From: [REDACTED] >
Sent: 17 February 2021 15:09
To: Planning <planning@ribblevalley.gov.uk>
Subject: Application No 3/2021/0076

Planning Application No N/2021/0076

Queen Mary Terrace and Bridge Terrcae Mitton Road Development Whalley BB7 9JS

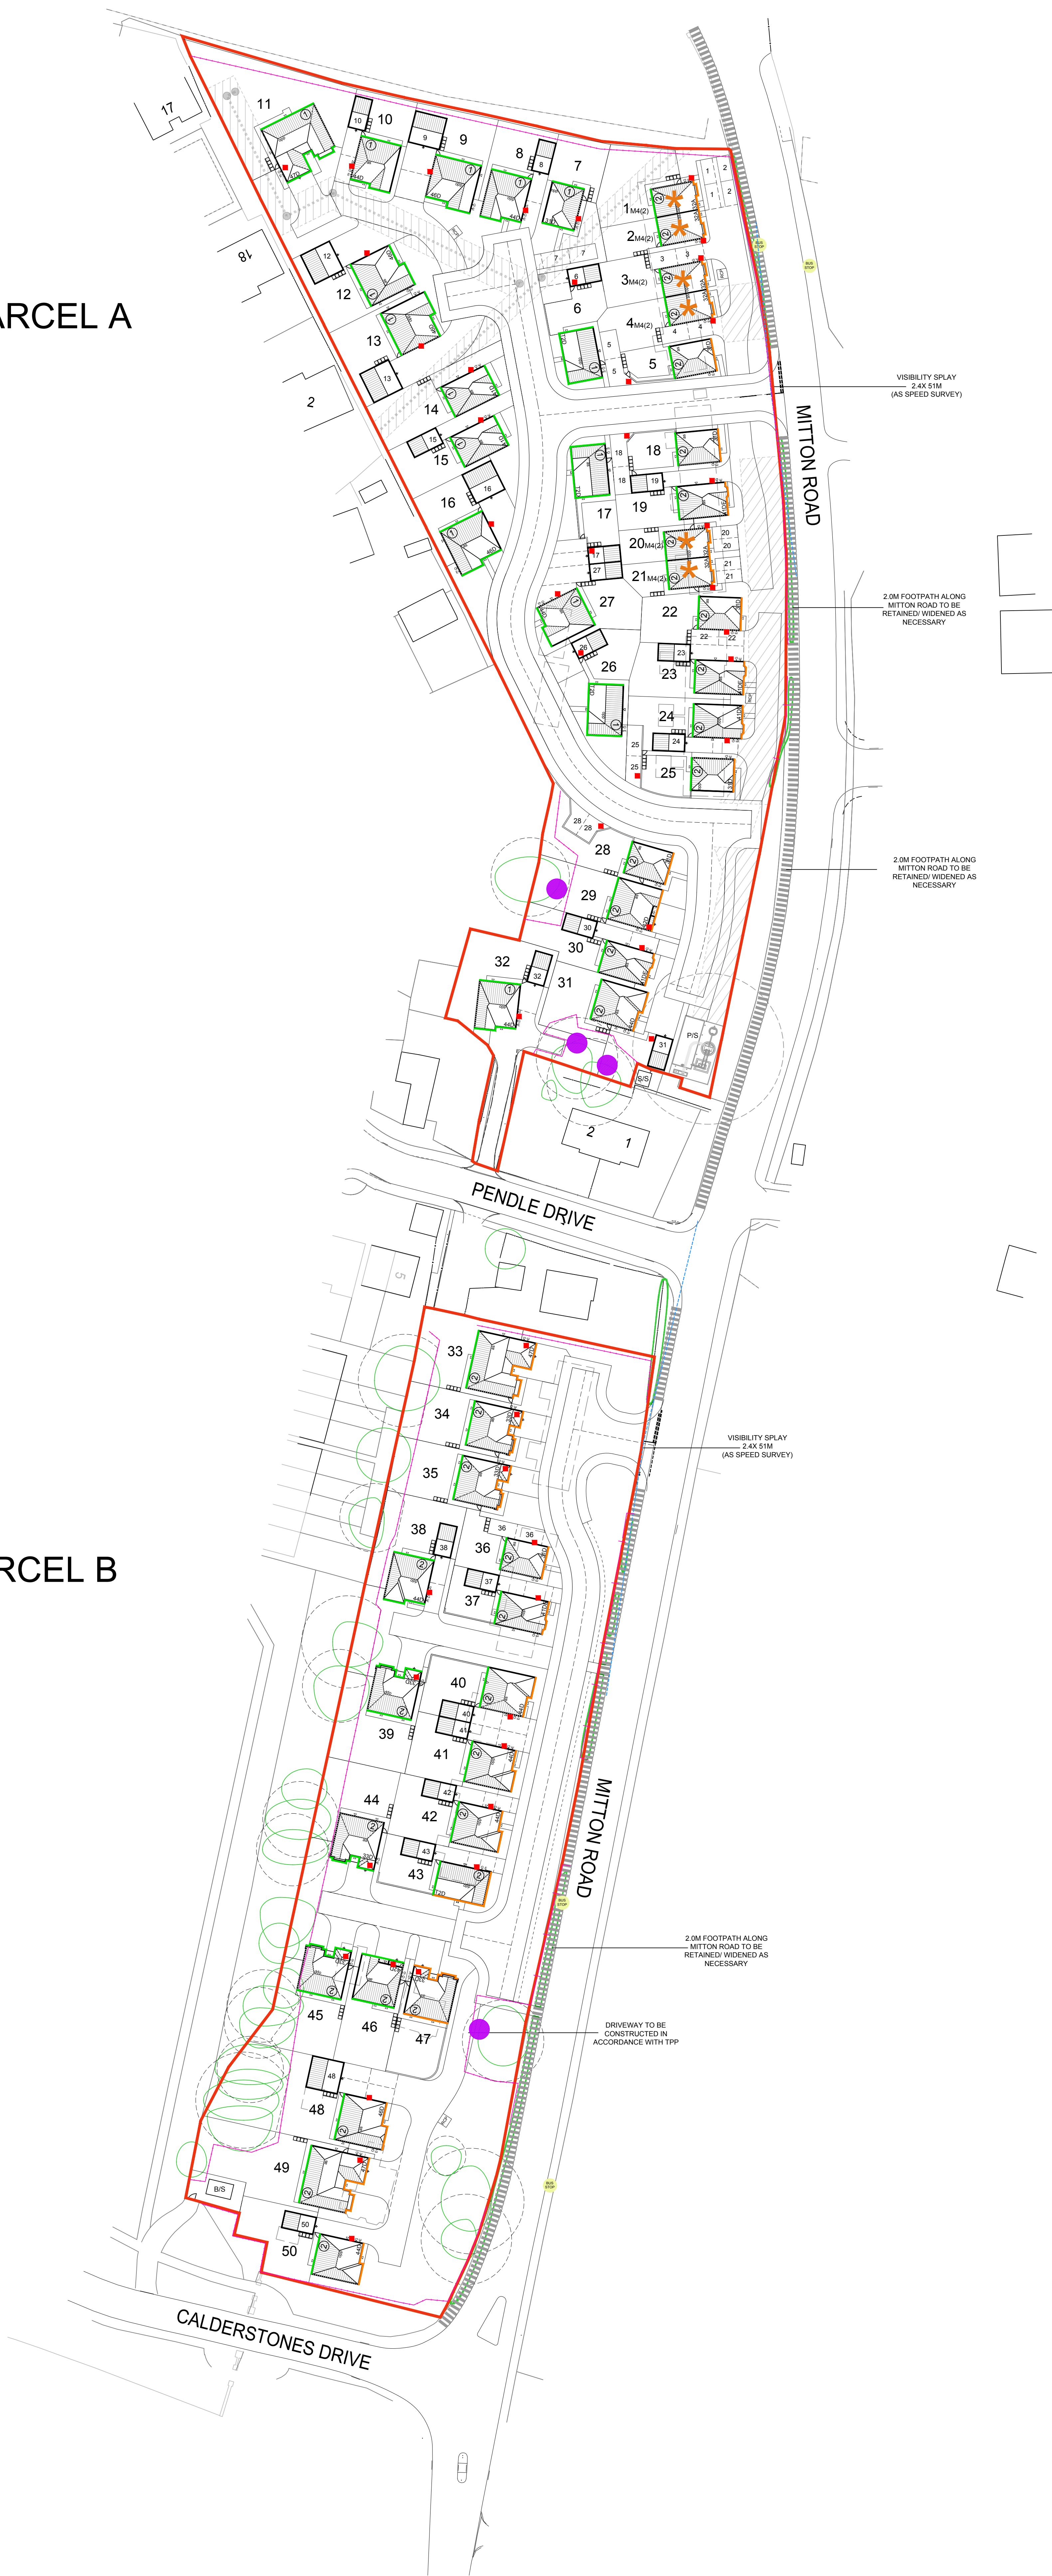
6. Now to the diagram. I'm not clear why an entrance on to Mitton Road is sensible. There seems to be an increased volume of traffic, especially of vast fast tractors coming in and out of the village along that road.

7. Icons Parcel A

Tree to be retained -
Canopy and root
protection area

'Tree to be retained'.

Parcel A. But there are No trees there 'to be retained'..

It marks out at least 10 of these icons in

Tree to be removed

8. Parcel B This icon is self explanatory. So I looked in Parcel B for these icons. There is a line of green blobs (retained?) but no indication of those to 'be removed'. Yet on the plan there is only one row, whereas at present there are two rows of trees – birches on right, beeches on left. Which ones are going to be 'removed'?
